Our Reference: 23/02043/HFUL

Site address: Streetly End Farm Streetly End West Wickham Cambridgeshire CB21 4RP

Proposal: Replacement single storey outbuilding.

LOCATION AND
 EXISTING BLOCK PLAN

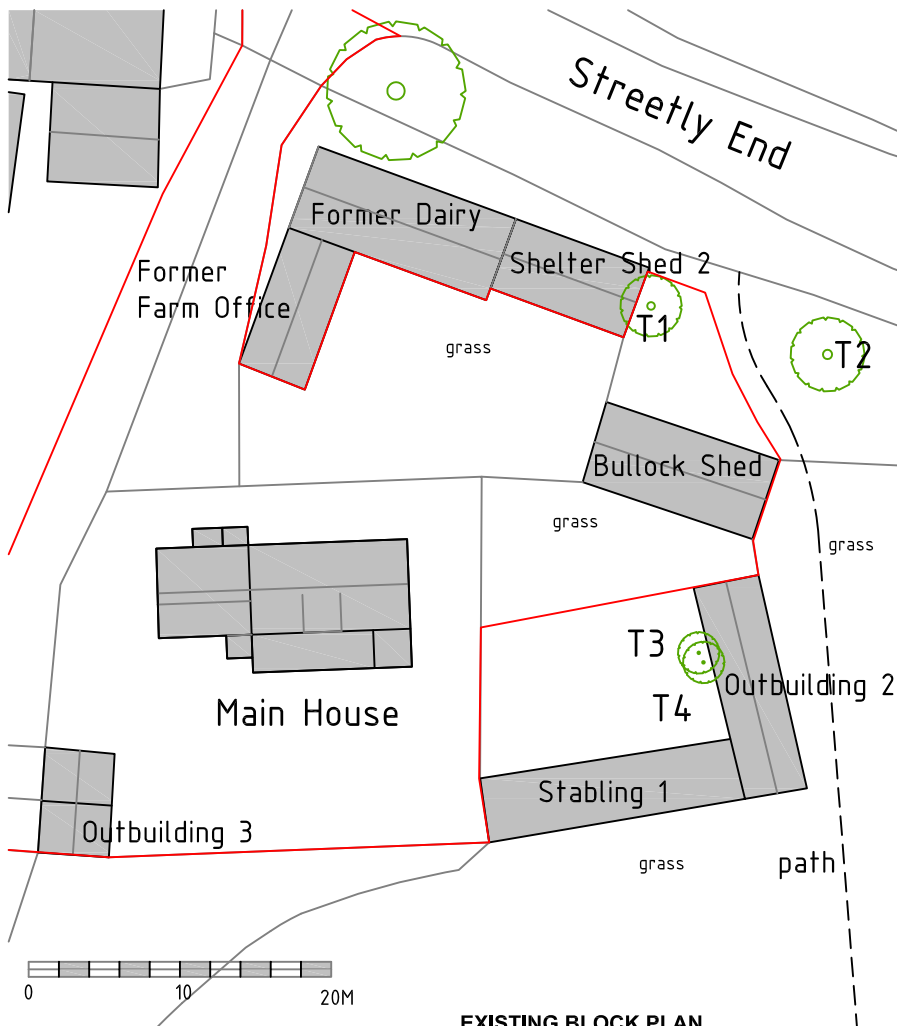
- If the application is for an outbuilding serving Streetly End Farm, then the red line in location plan must show a functional link to a dwelling for it to be considered as a householder application. Furthermore, it should include all land necessary to carry out the proposed development - Including any land required for access to the site from a public highway, If the application is for an independent dwelling, then the application will need to be withdrawn and resubmitted as a FUL application
- The proposal description should include the solar panels.
